REPORT UPDATE

Recommendation Report for Planning Permission

LOCATION: White Horses
9 Main Drive
Middleton on Sea

PROPOSAL: Demolish sub standard bungalow and erect 2 No. semi detached houses.

CLIENT:	Mr and Mrs Pendleton - 44 Southdean Drive Middleton on Sea	DESCRIPTION:	Site Block Plan - Drainage and Installation Plan
PROJECT:	Proposed Semi-detached 3 Bedroom Chalet Dwellings with Parking	SCALE:	1:500
DATE:	April 2013	REVISION:	DRAWING No: 13195/ 2

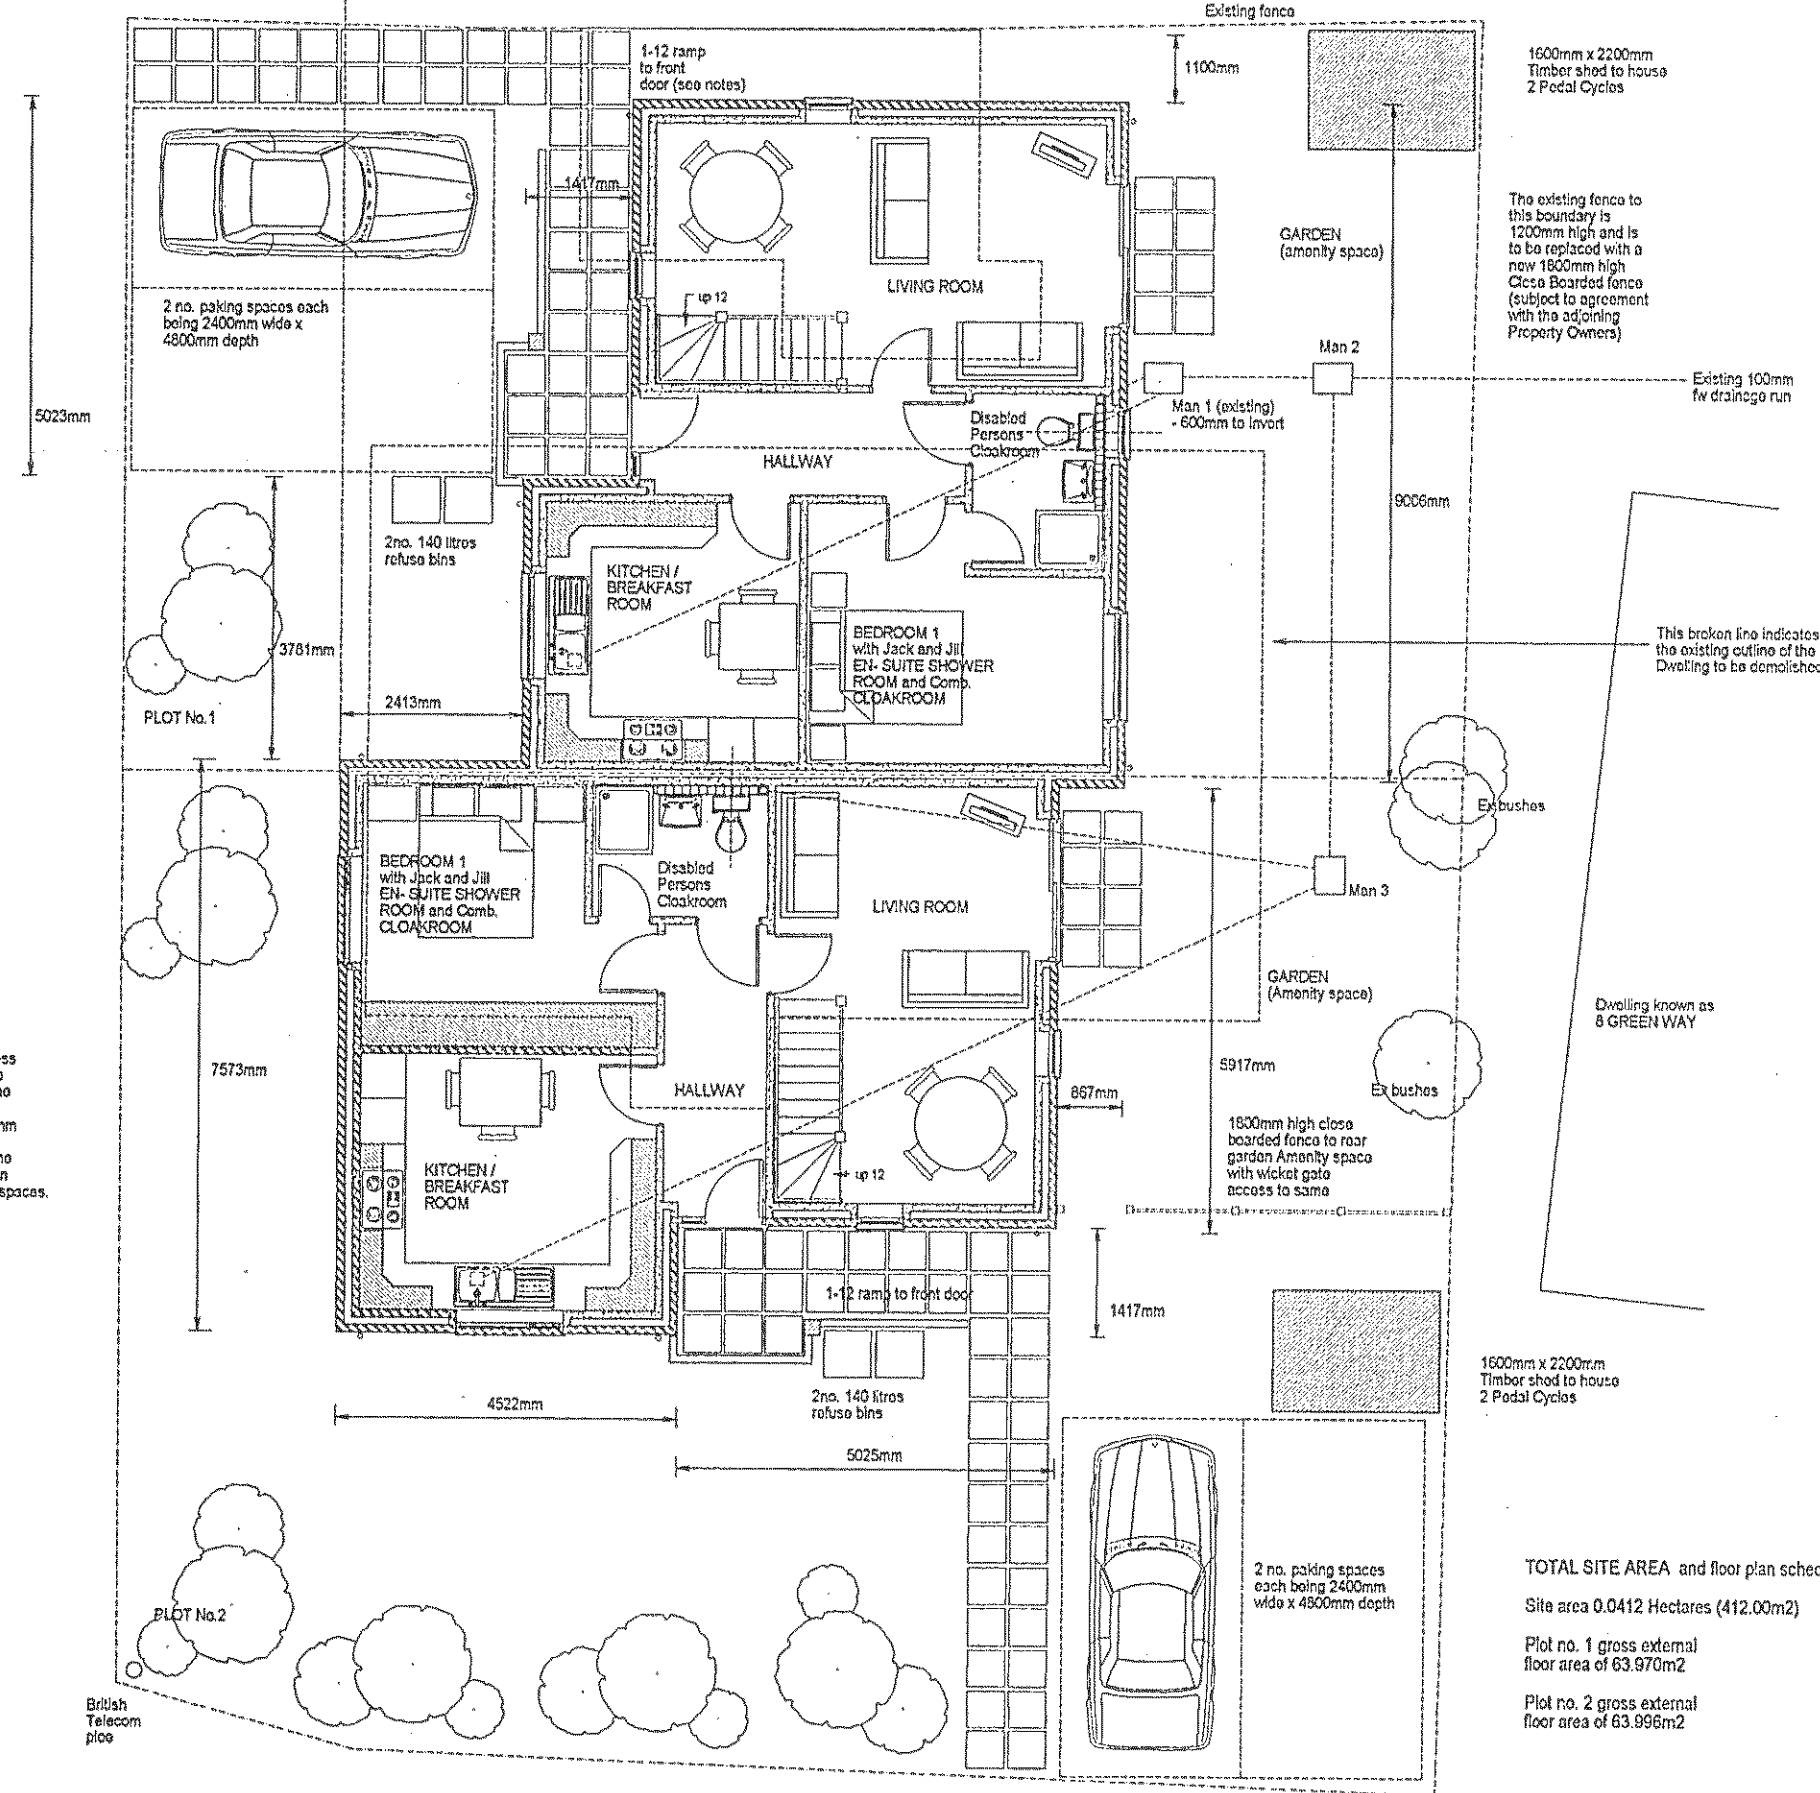
The site is located on a prominent corner site. The provision of 2 dwellings may be acceptable, but the layout as submitted represents an overdevelopment of the site where 2 x 3 bed dwellings cannot be satisfactorily accommodated. Little space is left around the development. The unit to the north is set back from the site frontage a greater distance than the adjoining properties to the north which results in a distance to the rear boundary of 4.5 metres resulting in a cramped appearance to the development which is out of keeping with the general pattern of development in the locality. The southerly unit fronting Greenway projects forward of no. 8 to the east and is considerably closer to the site frontage than the existing dwelling on the site. The height of the proposed development to the ridge would be 6 metres. Given its height and proximity to both road frontages it is considered that the proposal would be prominent and obtrusive in the street scene.

A rear garden depth of 4.5 metres to serve a family 3 bedroom unit is insufficient. The restricted space would be likely to result in an unacceptable enjoyment of outside amenity space by a family where the level of noise and activity in close proximity to the boundary is likely to cause disturbance to the adjoining dwellings to the east and north. Whilst the dwelling would be close to the rear boundary given the fact that it sides onto no.8 it is considered that any overbearing effects would not cause material harm to the occupiers of this property. In addition, there would be no adverse overlooking resulting since the only window in the rear elevation serves a bathroom.

With regard to impact on no.7a Main Drive it is considered that the 1 metre distance to the side boundary combined with the rear ward projection of the proposal of 2 metres and eaves height of 4.9 metres would result in a materially adverse overbearing effect.

CLIENT:	Mr and Mrs Pendleton - 44 Southdean Drive Middleton on Sea	DESCRIPTION:	Proposed Floor Plans - Roof Plans - Plots 1 and 2
PROJECT:	Proposed Semi-detached 3 Bedroom Chalet Dwellings with Parking	SCALE:	1:100
DATE:	April 2013	REVISION:	DRAWING No: 13195/ 3

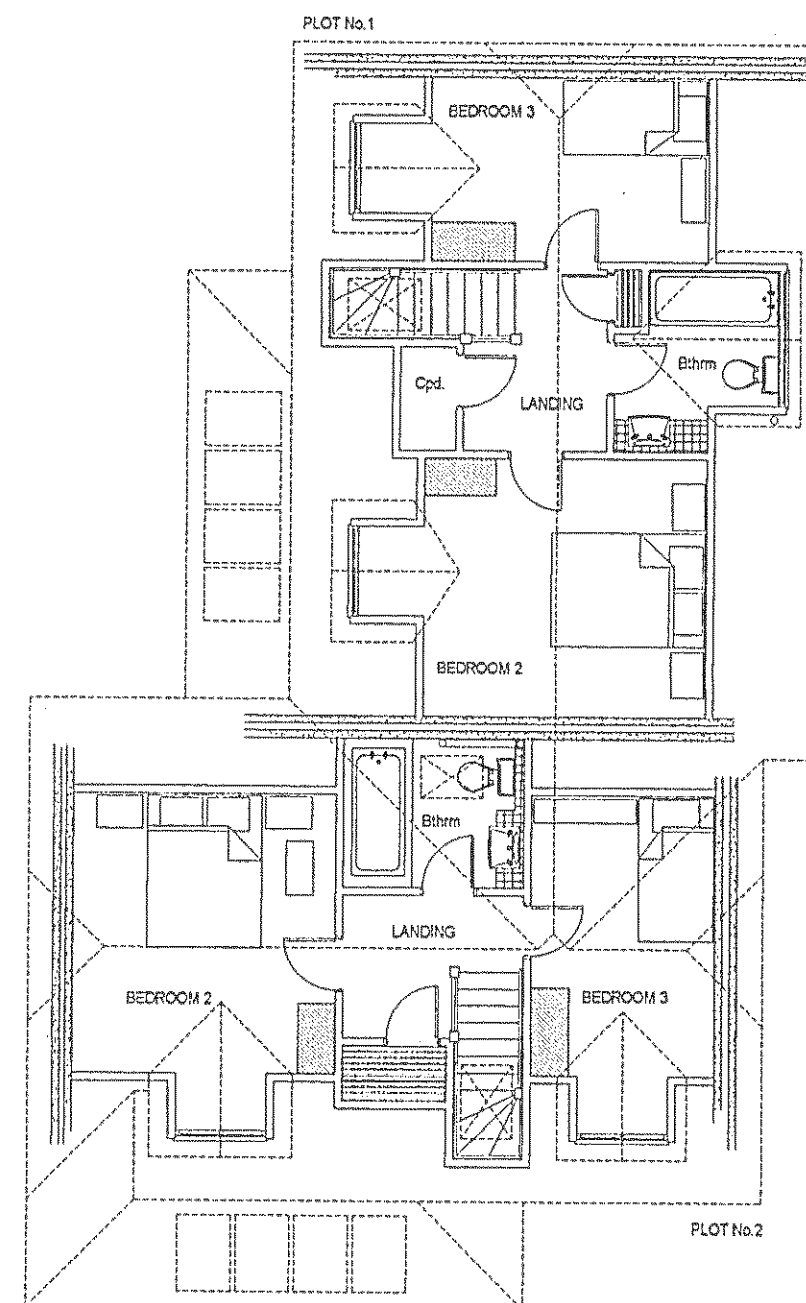
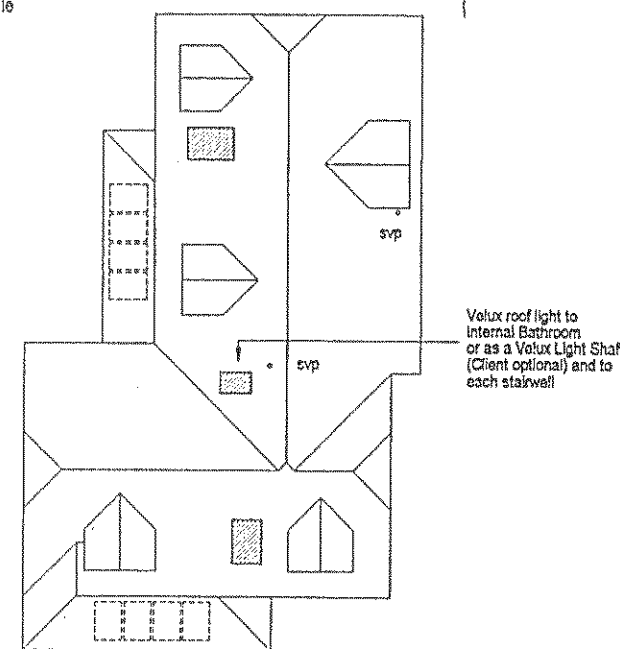
The current proposal has reduced the height of the dwellings. They are now chalet style instead of full 2 storeys, but each dwelling still has 3 bedrooms. Both earlier applications included the provision of a garage and parking space to each unit. This proposal contains no garaging. 2 parking spaces are identified for each unit adjacent to the road frontage.
